**Summary of Comments on Issue Specific Hearing 2:
Environmental Matters
for the
Royal Society for the Protection of Birds**

**Application by Alternative Use Boston Projects Limited for an
Order Granting Development Consent for the
Boston Alternative Energy Facility**

Planning Inspectorate Ref: EN010095

**SURFACE WATER
DRAINAGE CATCHMENTS
FIGURE 13.1**

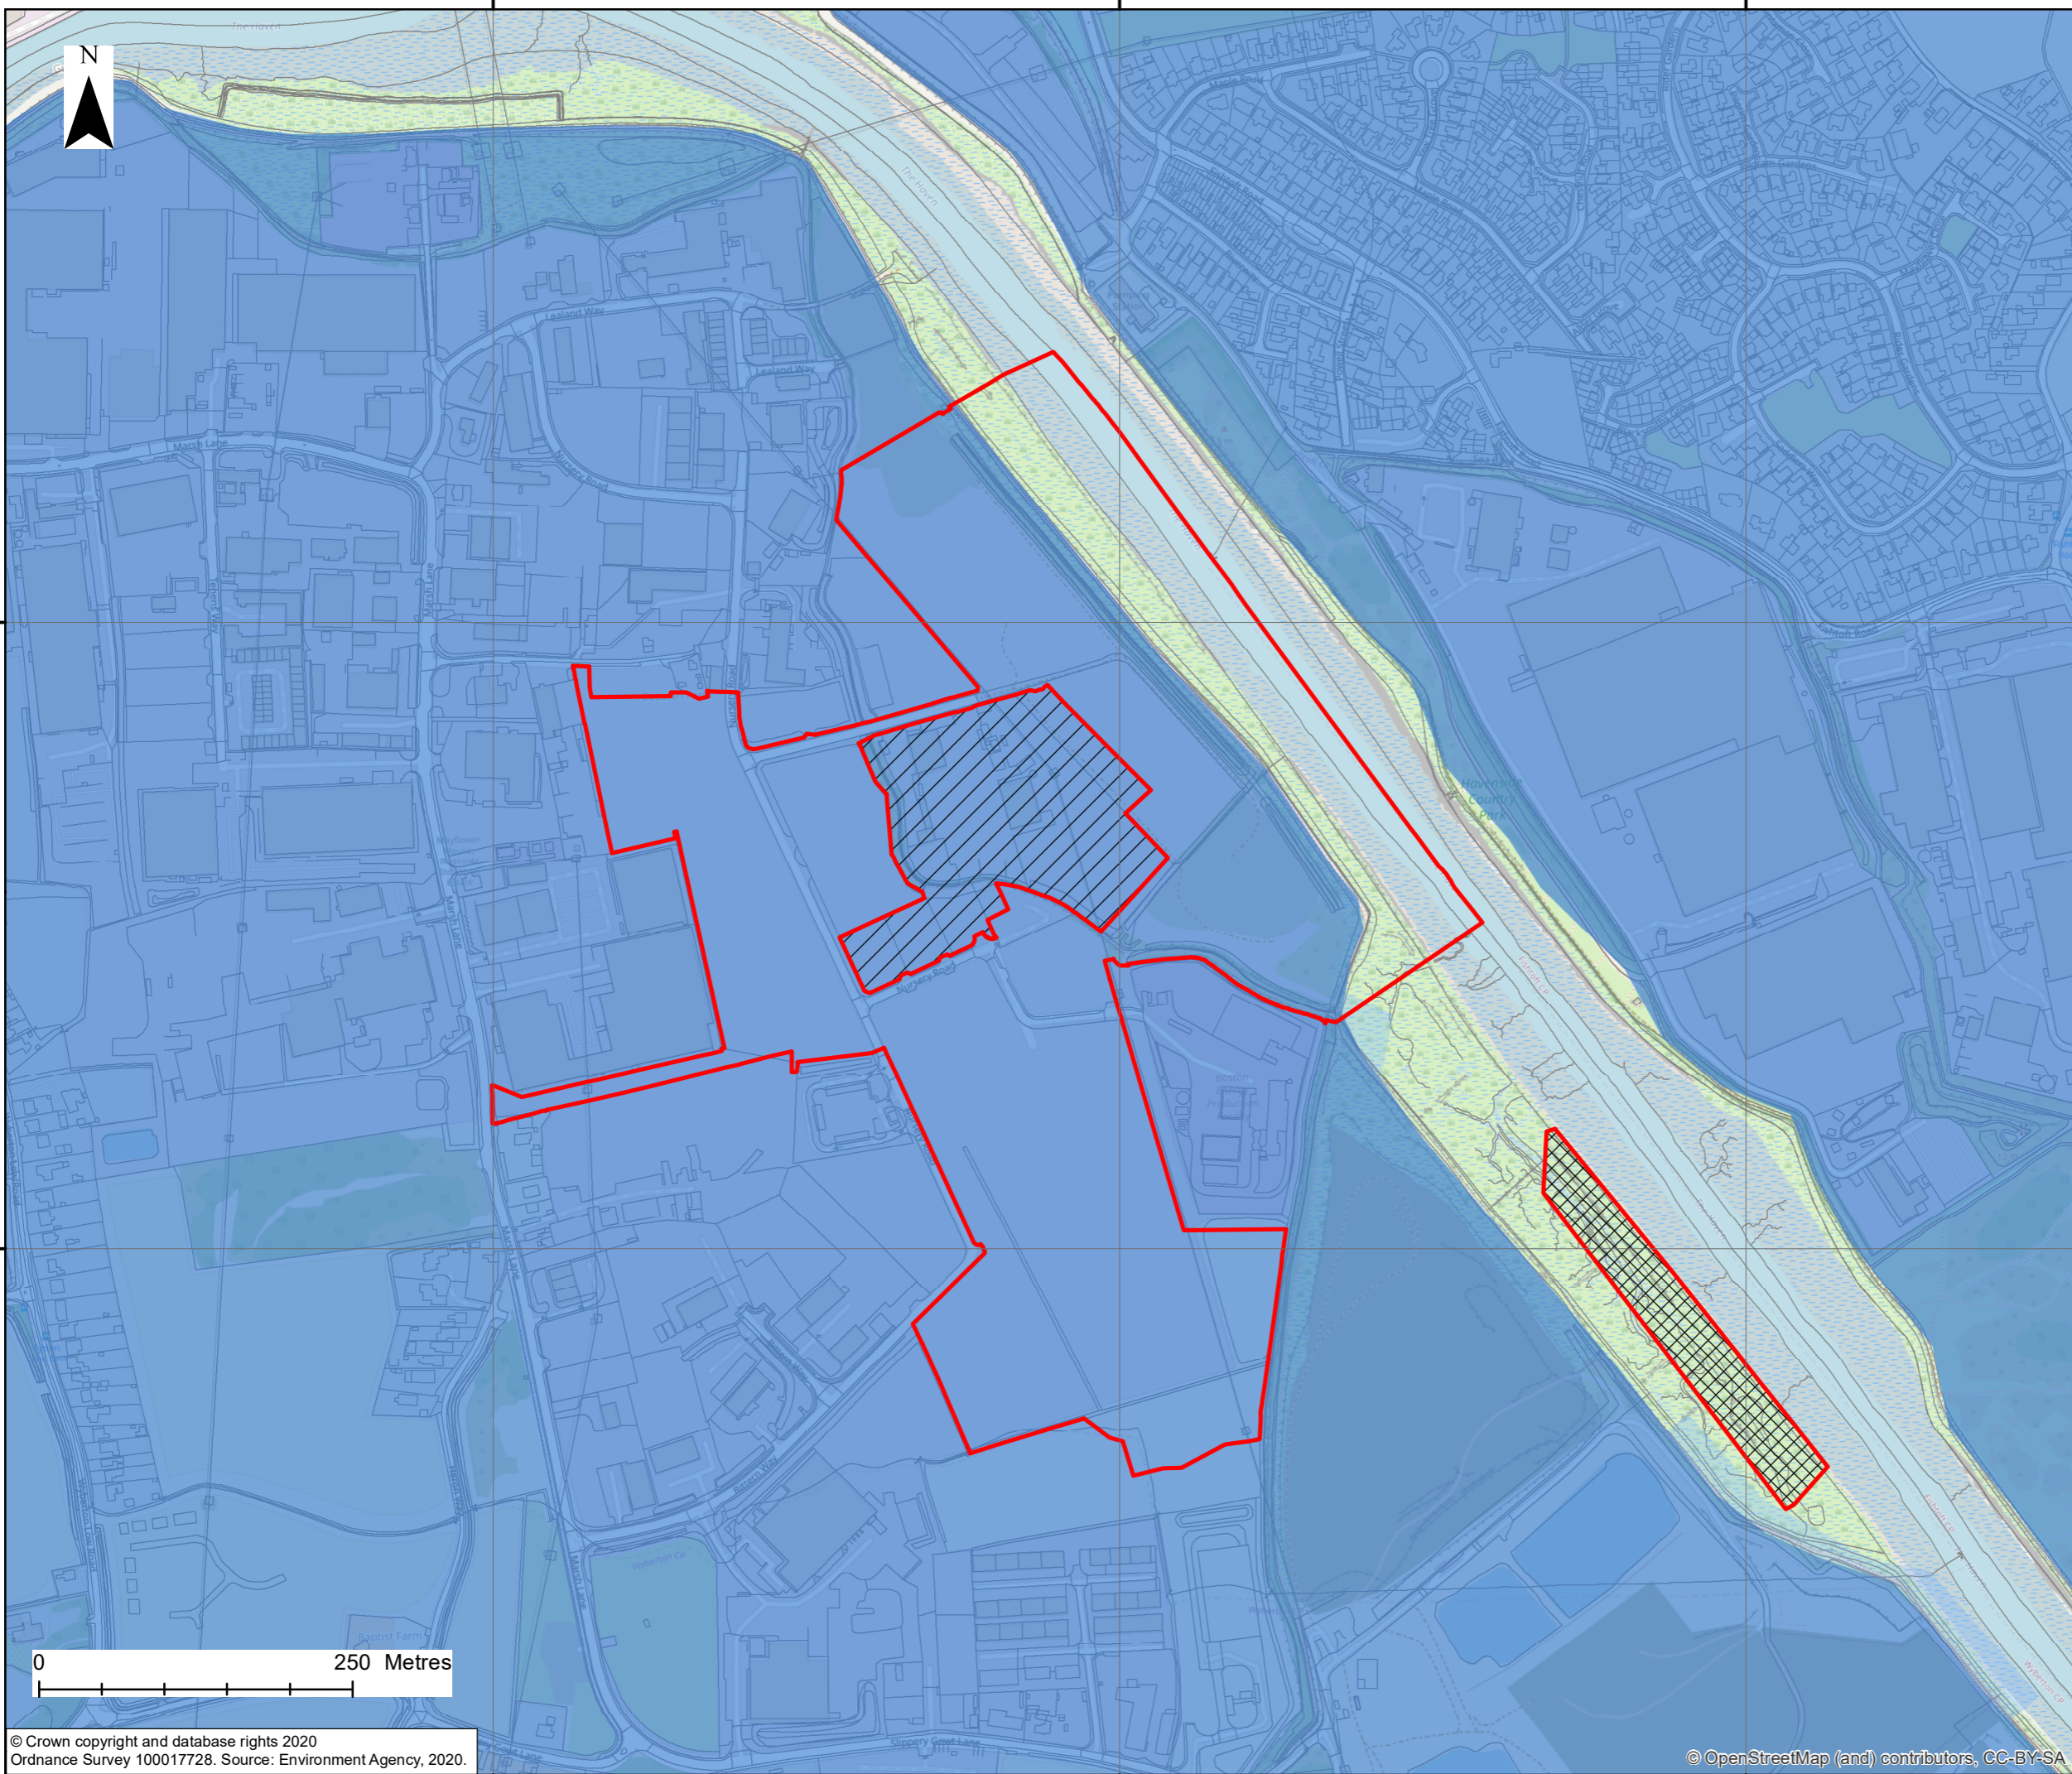
- 2.1 The RSPB highlights that we have concerns about surface water drainage, which we submitted at Deadline 2 (REP2-052). We consider the issue of surface water drainage is also a key consideration for the Habitats Regulations Assessment.
